DECISION DELEGATED TO HEAD OF PLANNING

Application No: H19-1062-22 **Applicant:** Mr J Plater

Proposal: Extension to existing bungalow and creation of first floor in roof space.
New double garage with loft storage above approved under H19-0907-20.
Modification of Condition 2 to allow amendments to previously approved plans.

Location: Sunleigh 125 Lutington Gedney Hill

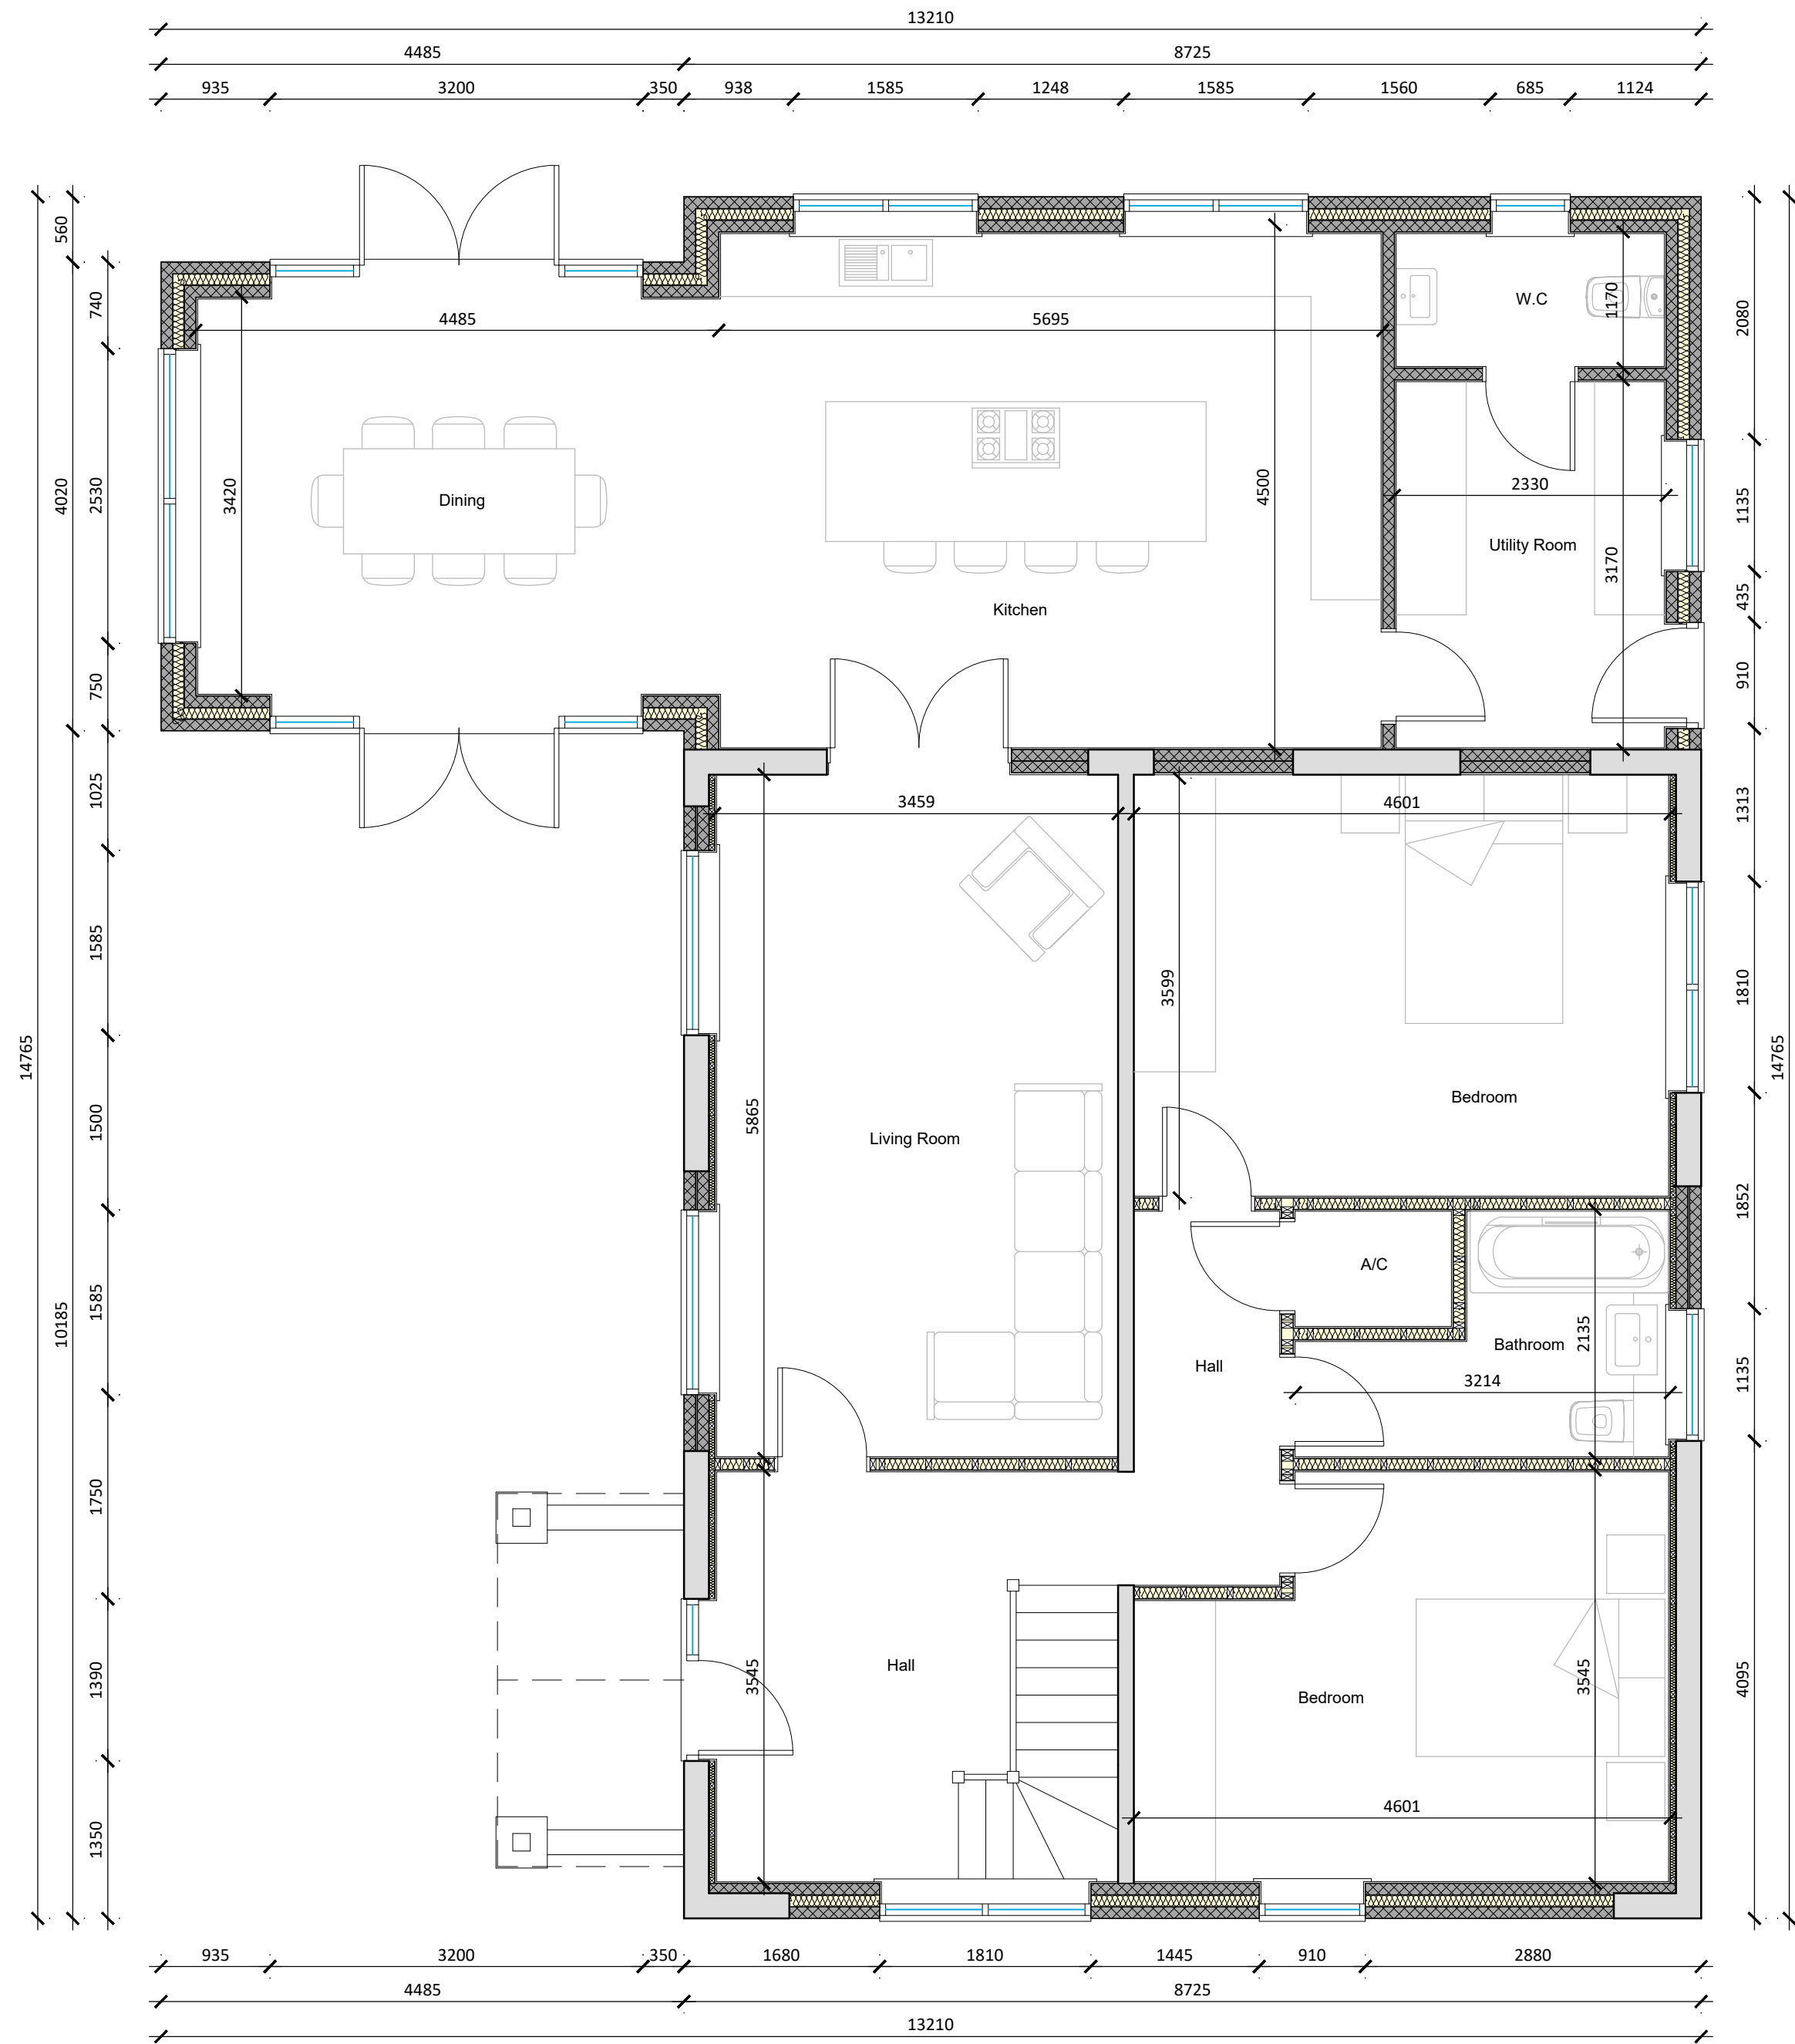
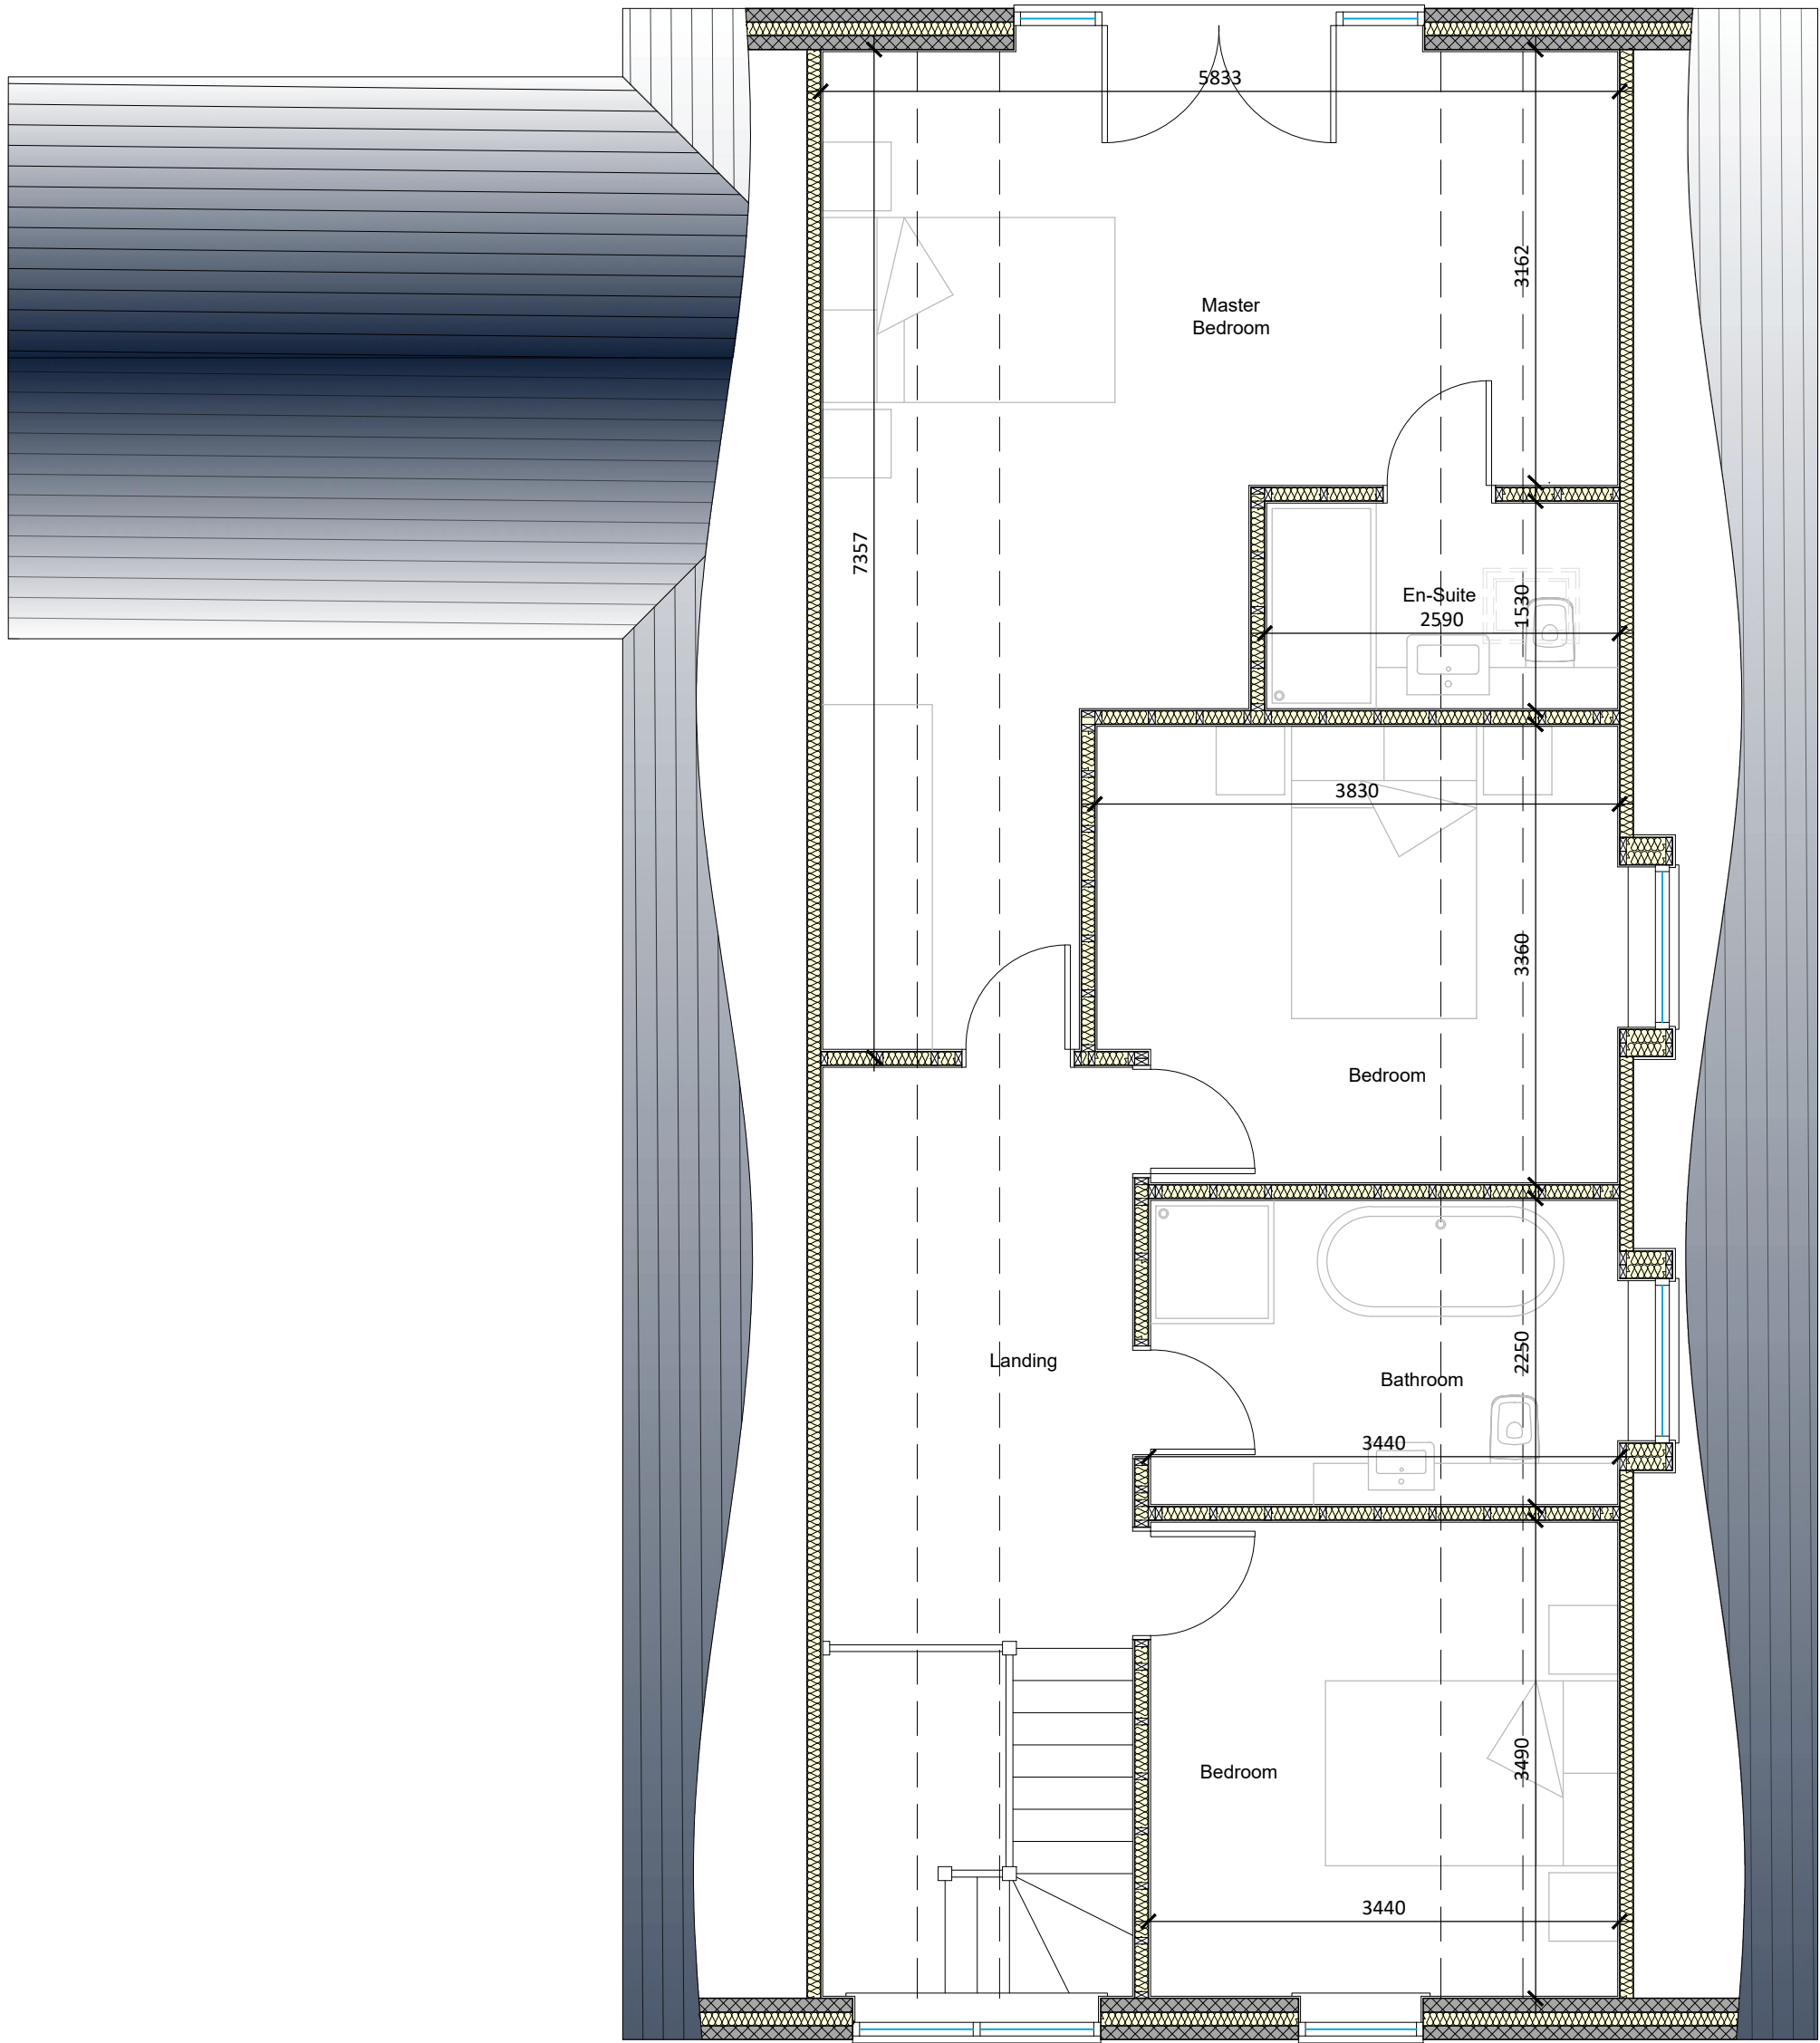
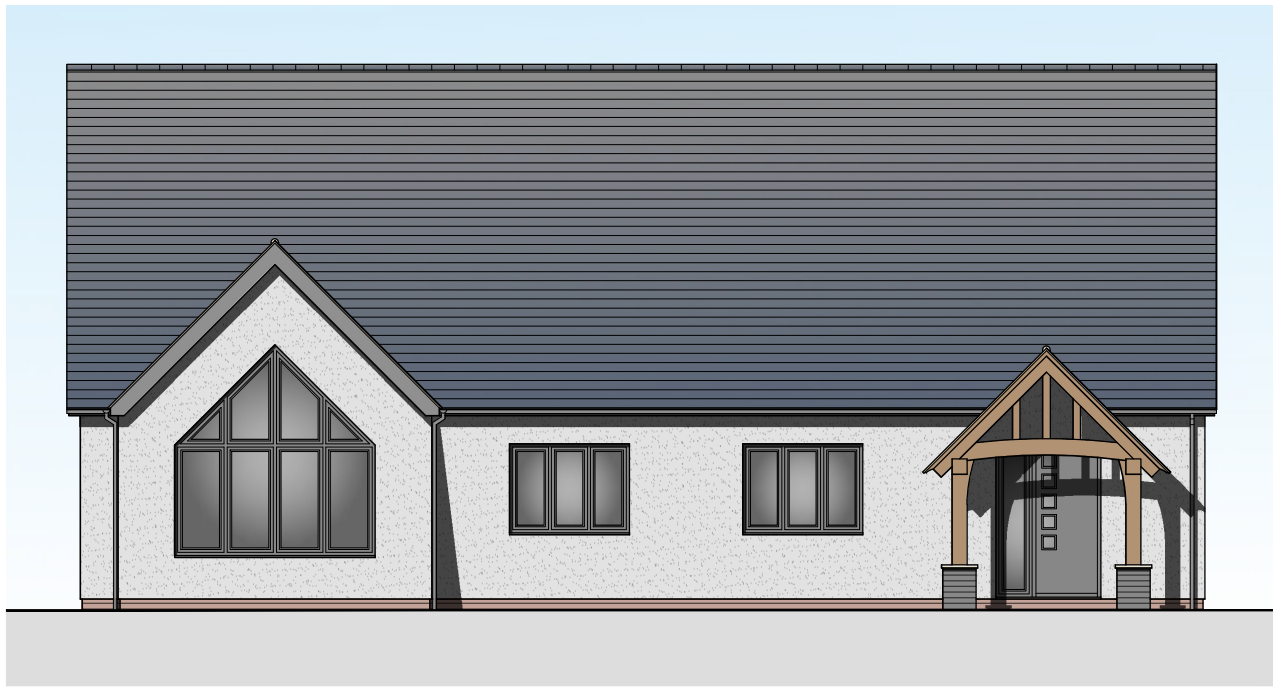
Proposal is for an extension to the existing bungalow and creation of first floor in roof space, along with a new double garage with loft storage above. The proposal was originally approved under H19-0907-20. The application is for the modification of Condition 2 to allow amendments to previously approved plans. The changes to the original approved plans are minor, involving, predominately,

internal changes to the positioning of walls of less than 100mm. A reduction in the extension of the north-west dining room wall of 80mm is the only external change to the original approved plan.

As the amendments to the previously approved design are incredibly minor and predominantly internal, similar considerations, with regards to scale, can be considered as with the original proposal. The change in the north-west exterior wall of the dining room is insignificant, and therefore, will have little impact on the residents or neighbours.

Visually, the amended proposal is in keeping with the original design. Currently the property is still under construction, so limited comments can be drawn from present appearance. The existing brickwork will be rendered in white on all elevations. The existing clay tiles will be replaced for faux blue slate. White UPVC will be replaced for identical material but in grey. In contrast, facing brickwork is proposed for the detached garage. The proposed material schedule will significantly upgrade the appearance of the dwelling without harming the character of the area. The few properties in the vicinity were individually designed and there is no well-defined pattern of appearance.
